ExQ3.3.1 Further response from Mary Rance (20031504) relating to works plan 2/5

PROJECT: Longfield Solar Farm
TITLE: Works Plan Sheet 4
CLIENT: Longfield Solar Energy Farm Ltd
DATE: 15.09.22 **SCALE:** 1:2,500@A1
DRAWN: EL **DRAWING NO.:** 4077_LGF_DR_PRE_0008.4 **tel:** +44 (0)1904 715 470
CHECKED: RS **REVISION:** 1

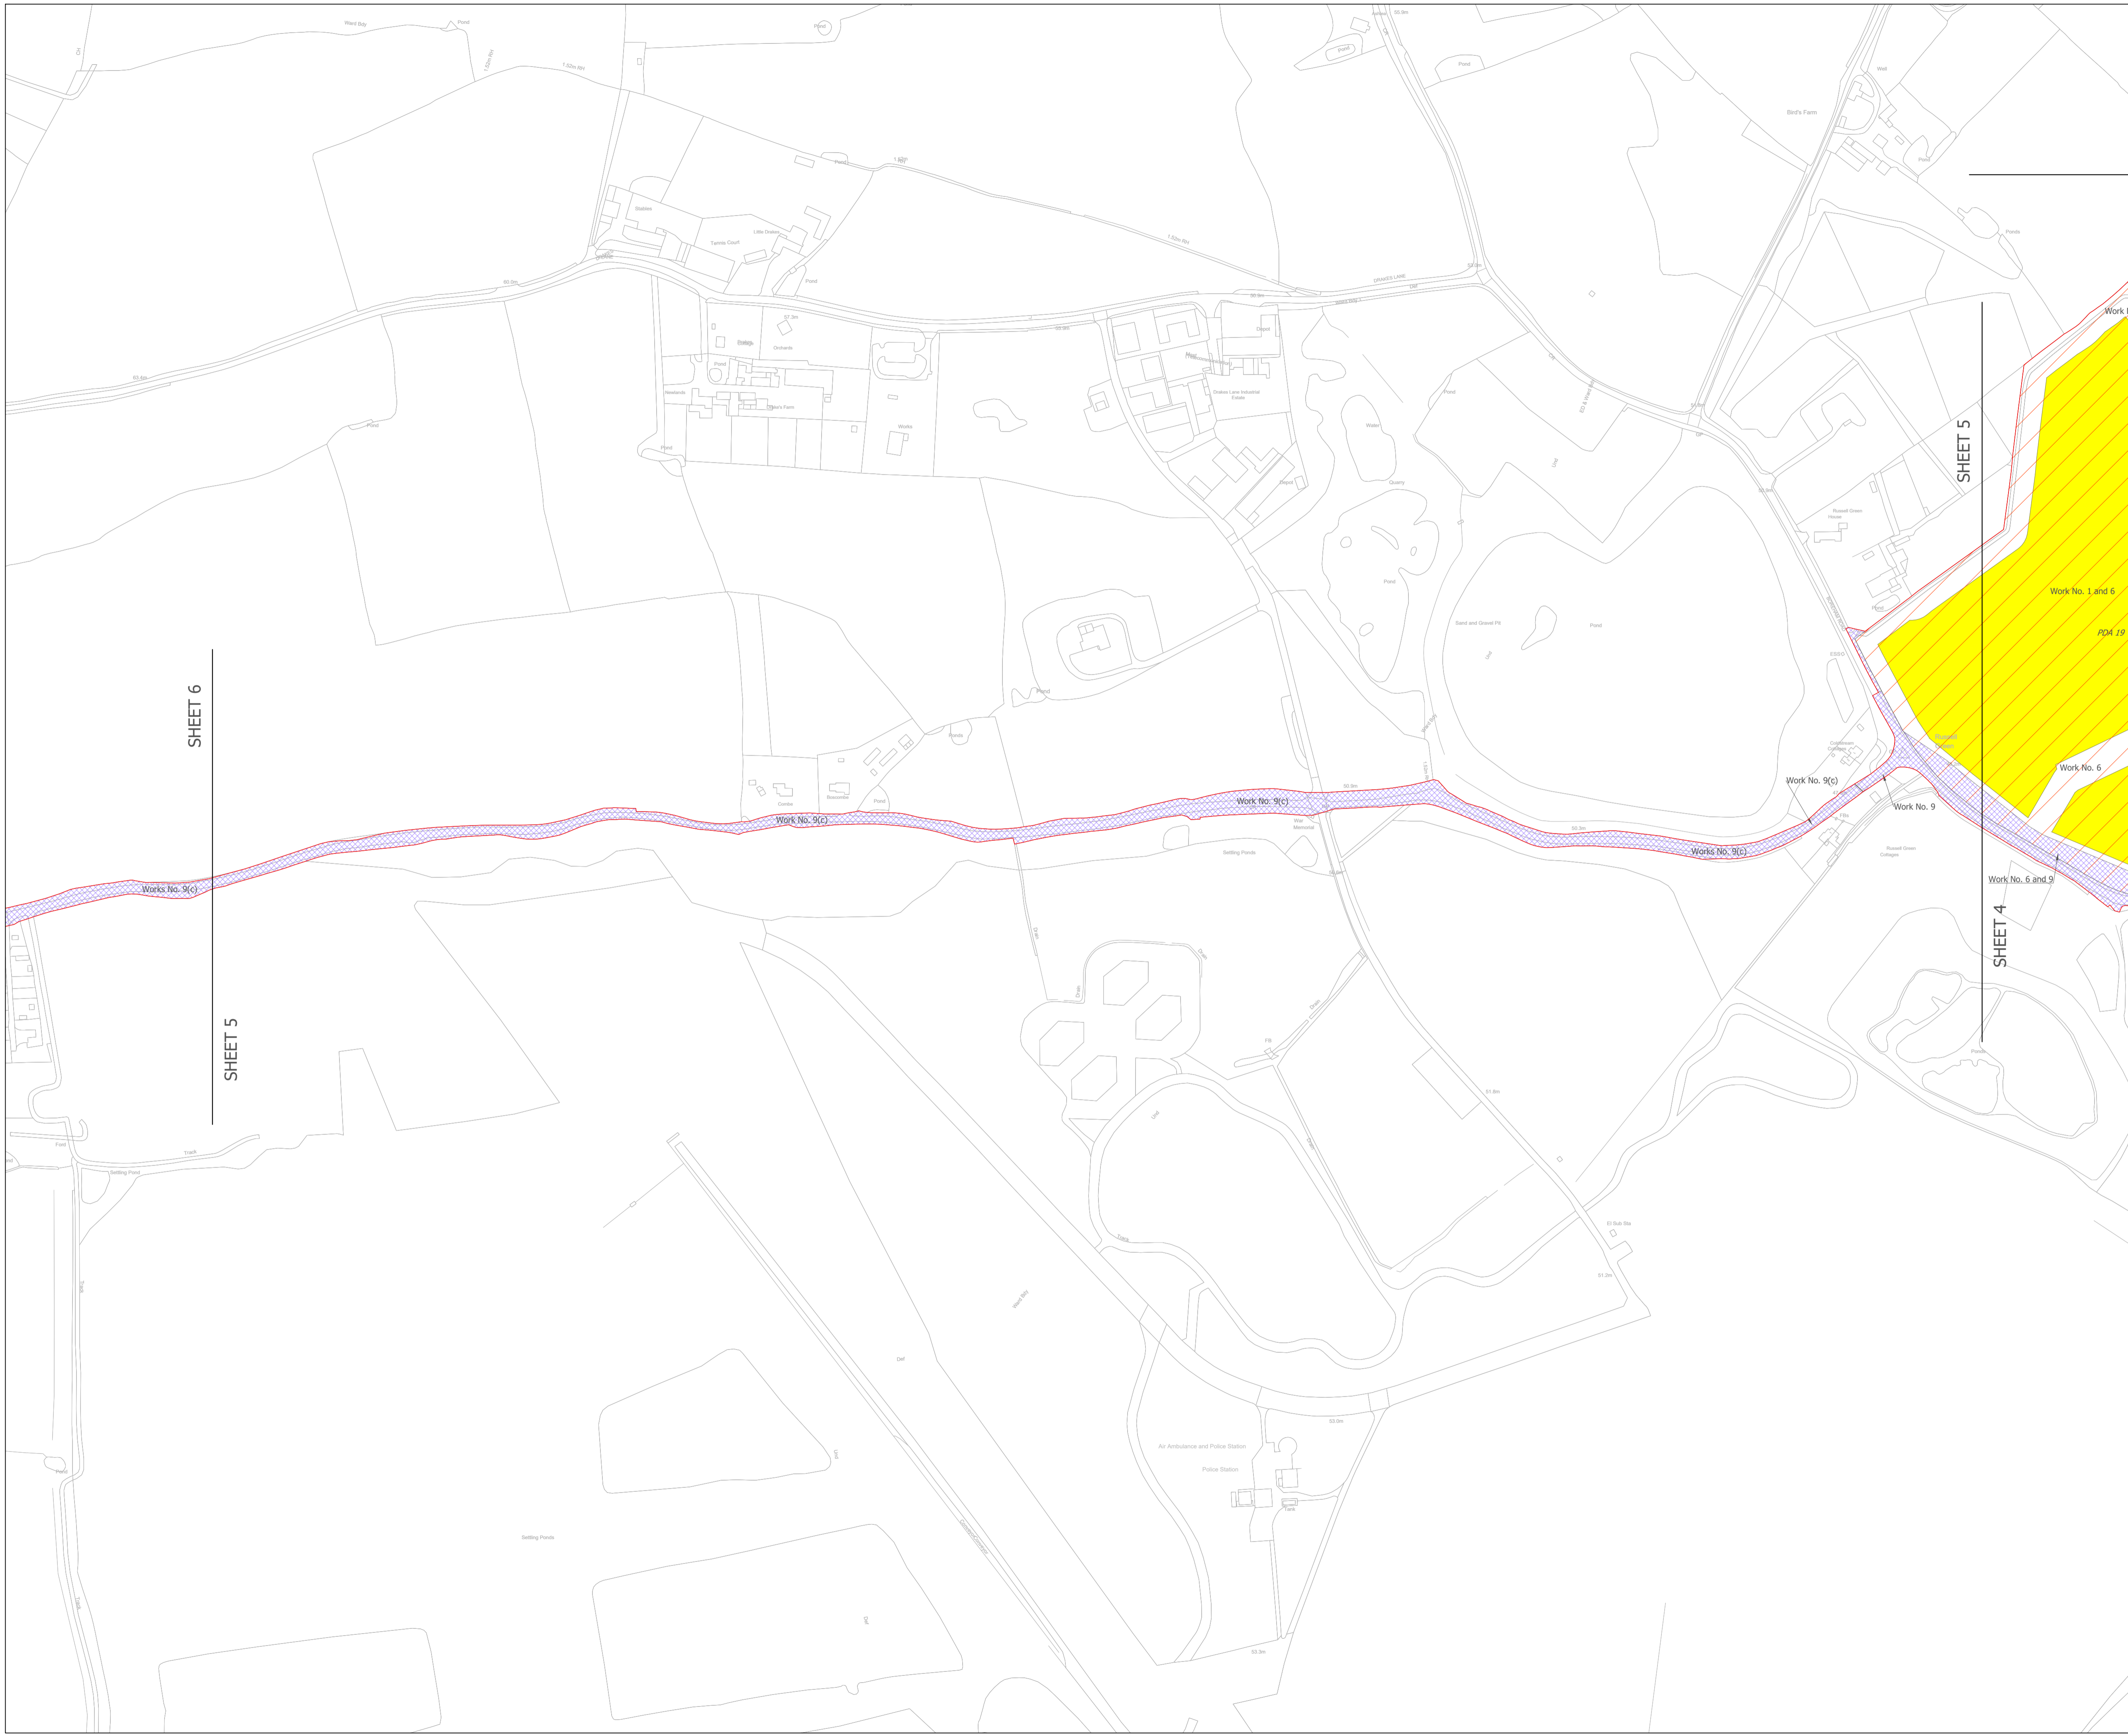
Longfield have responded to my submission at deadline 6 (REP6-074) and given references to their Arboricultural Report on the hedging between my field (2/6) and Waltham Road (Works Plan No 4). Following an enquiry by my agent to Gateley Hamer as to what the Applicant's intention is regarding this hedge, their written answer is '*As detailed within the vegetation plan submitted in the DCO the project has no right to remove existing vegetation within your client's land.*'

The Arboricultural Report shows a substantial portion of trees and hedging to be removed. I object to this significant loss and the ecological and visual impact it will have. My understanding is that the proposal is to run the cables through my land and across the road; this will involve turning the cables and there will be an associated permanent inspection chamber. There is also to be a temporary road surface in the field for associated vehicle movements. Given these specific works, the level of vegetation removal seems excessive.

In spite of the absence of plan 2/5, by searching the Application I have found the Traffic Management Plan and believe that what Longfield are aiming for is a temporary road that will not only facilitate the trenching programme, but also serve as a through road from Toppinghoehall Wood to Bulls Lodge. This would be alongside the trenching and accounts for the large amount of vegetation they want to demolish. It also explains why they want a temporary compound on my land for traffic to wait in until traffic lights allow them to cross.

Heavy construction traffic would be using this crossing and because there would necessarily be parking and turning in field 2/6 I feel strongly that it puts an unfair load on my land. It would require a much longer period of time for activity to continue here than is necessary – in fact, for the duration of the long trenching that continues to Bulls Lodge. I believe that my field would scarcely survive such use. This traffic would also be crossing and re-crossing the mains water supply that runs along the eastern verge of Waltham Road.

There is already a vehicle track on Lord Rayleigh's land from the woodland to Waltham Road at a point that is only a short distance from this proposed temporary vehicle crossing. Is there any reason why this cannot be utilised? And, surely, it should be preferred to third party land. If this plan could be used, it would not be necessary to remove quite as much vegetation as is envisaged on my boundary, in an area where there is going to be significant clearance of it on both sides of the road.
